**Bersted
Parish Council**

1st February 2012

Re: BE/151/11 Shripney Caravan Park

SHRIPNEY GARDEN CARAVAN PARK, SHRIPNEY LANE, SHRIPNEY
Proposals 01 B
Nov 2011

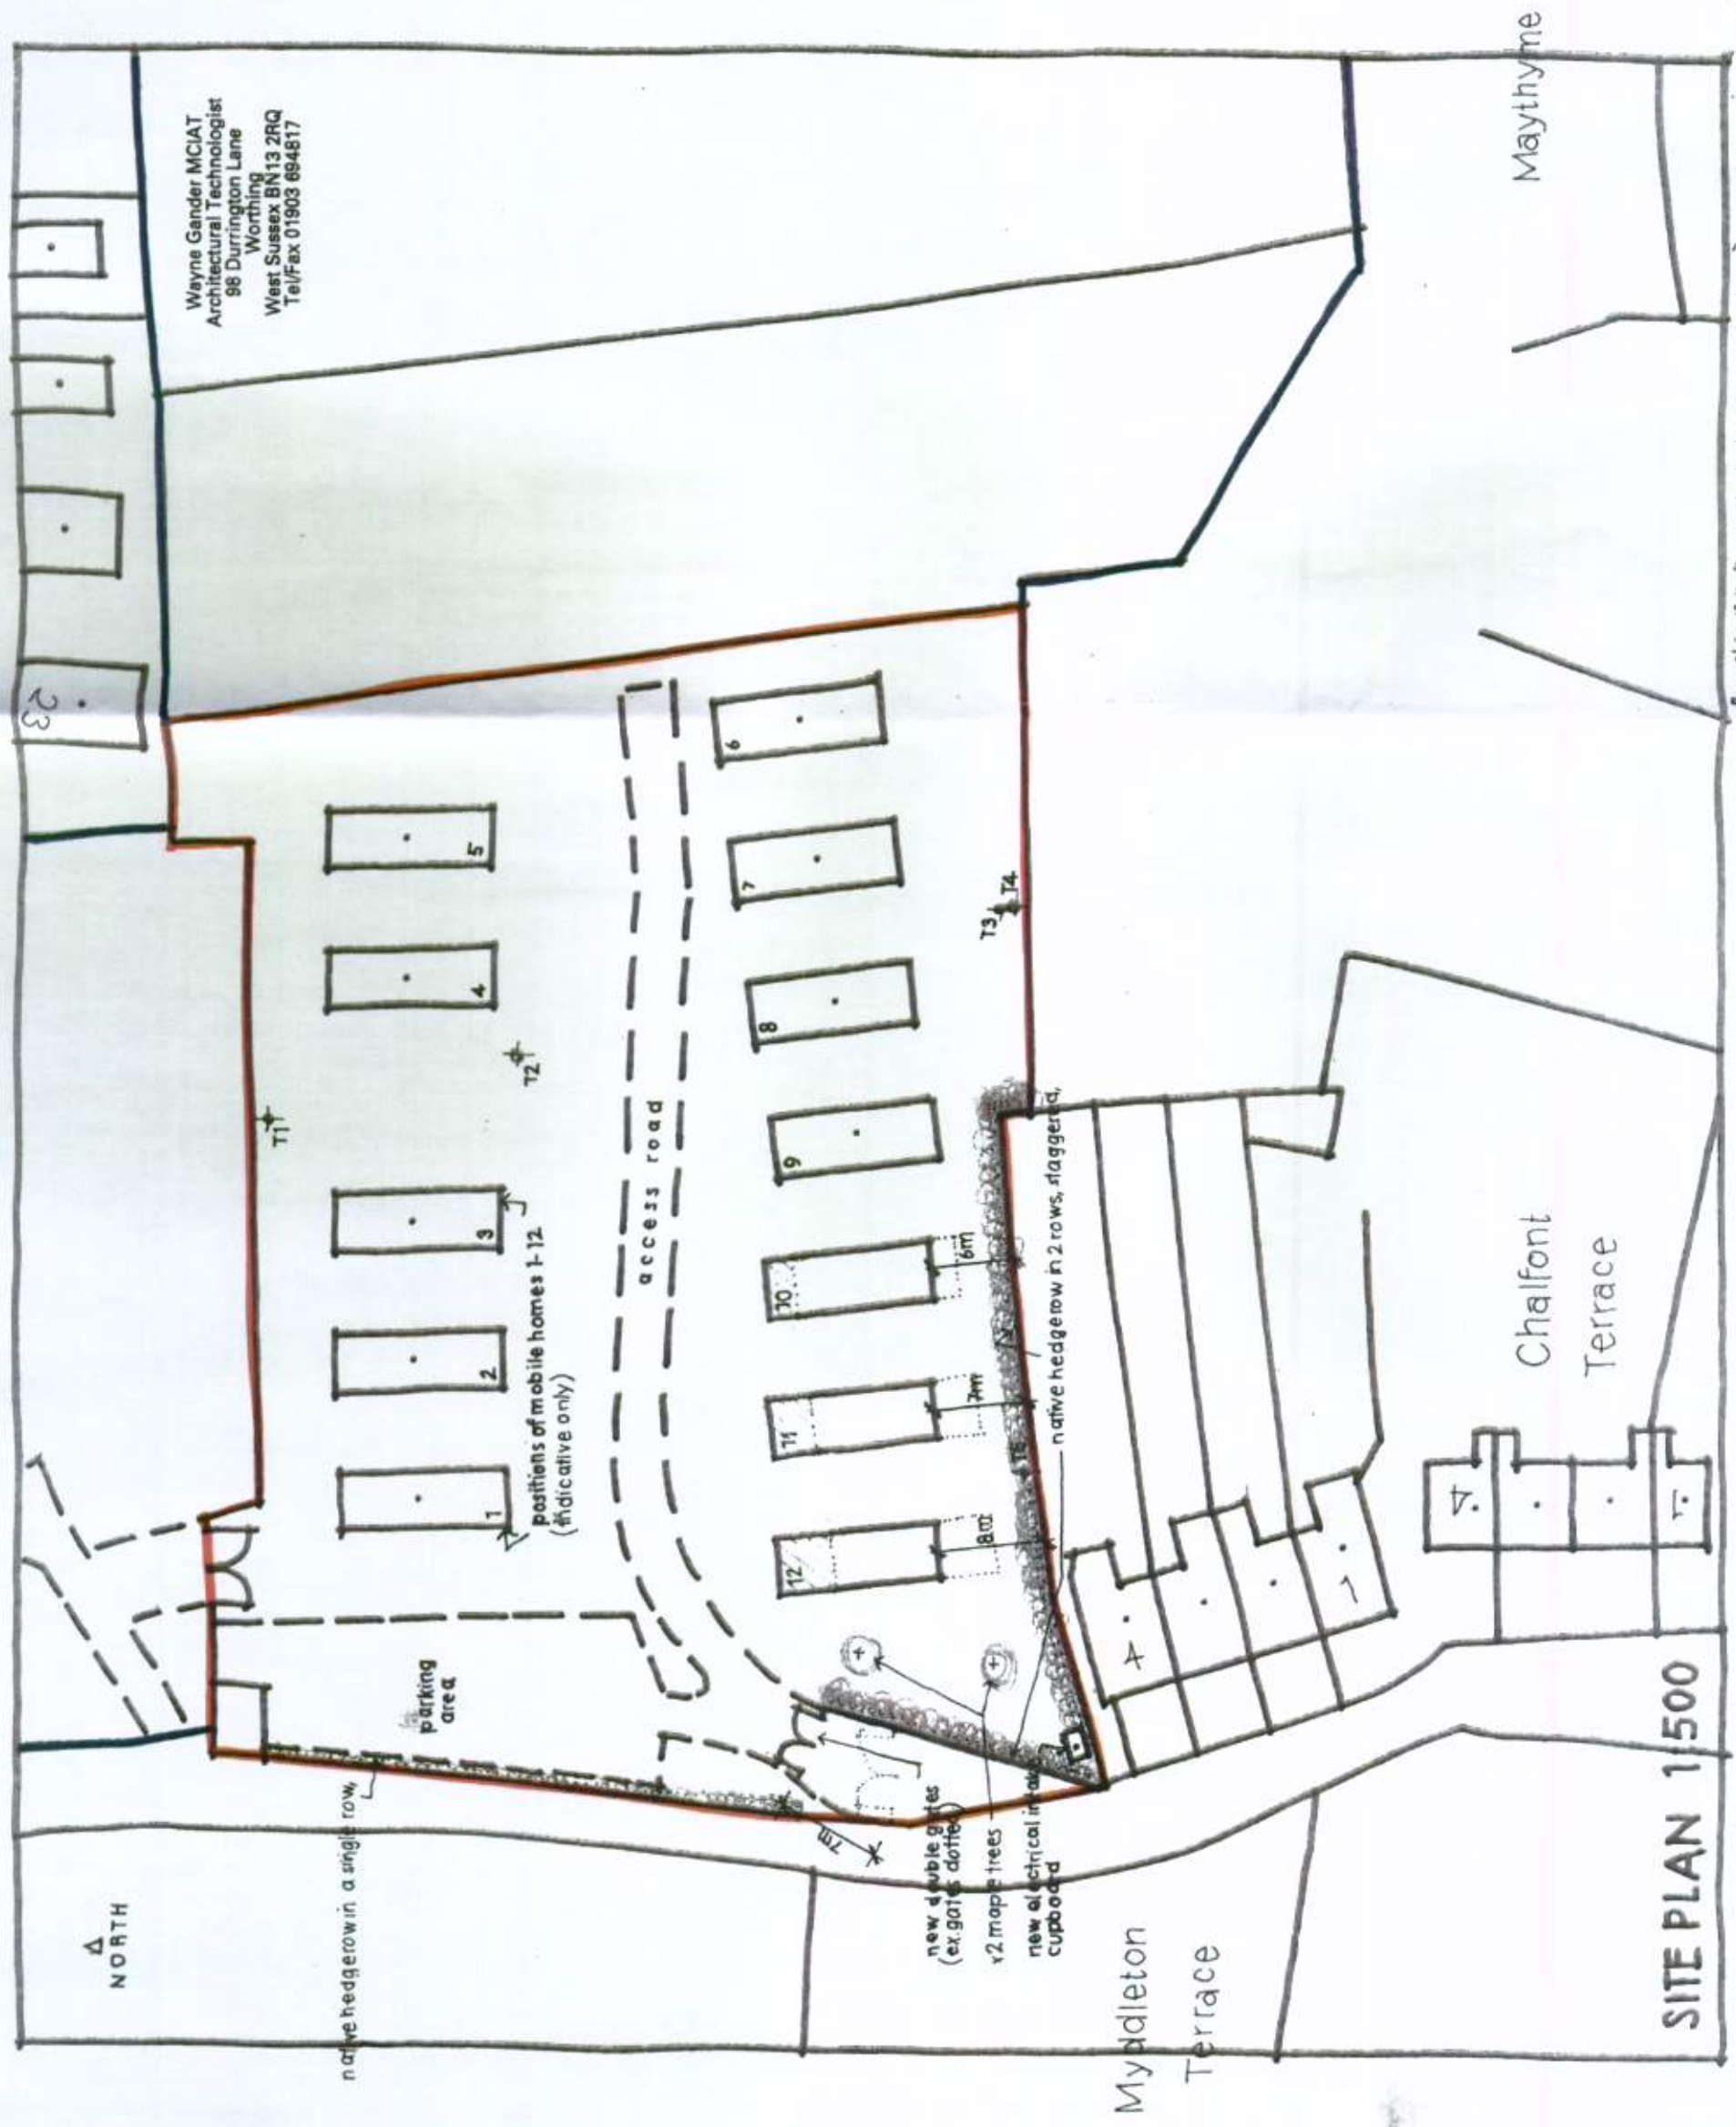
As clerk, and on behalf of the Planning Committee, I would like to inform you that the council does not have an objection to the above planning application modification. Members visited the caravan park on Monday 30th January. The caravans nearest to the residents will now be moved further away, partial landscaping has taken place and the gate moved in order to accommodate vehicles off the access road. Members agreed that these measures would mitigate the position of the caravans in relation to the existing residents

- Privacy. Mrs Jolley, the resident most directly affected, does not think the landscaping will be a good enough barrier. The landscaping is very immature at the moment and quite sparse, it is hoped that more dense, native flora could be added to screen and shelter.

- the new entrance should be for caravans only. In order to minimise engine noise and pollution all other vehicular access should be from the other entrance further away from the existing housing.

I would appreciate it if you can confirm that the existing landscaping will be increased to include native flora which does create a barrier and further thought is given to the possibility of vehicular restriction at the first entrance.
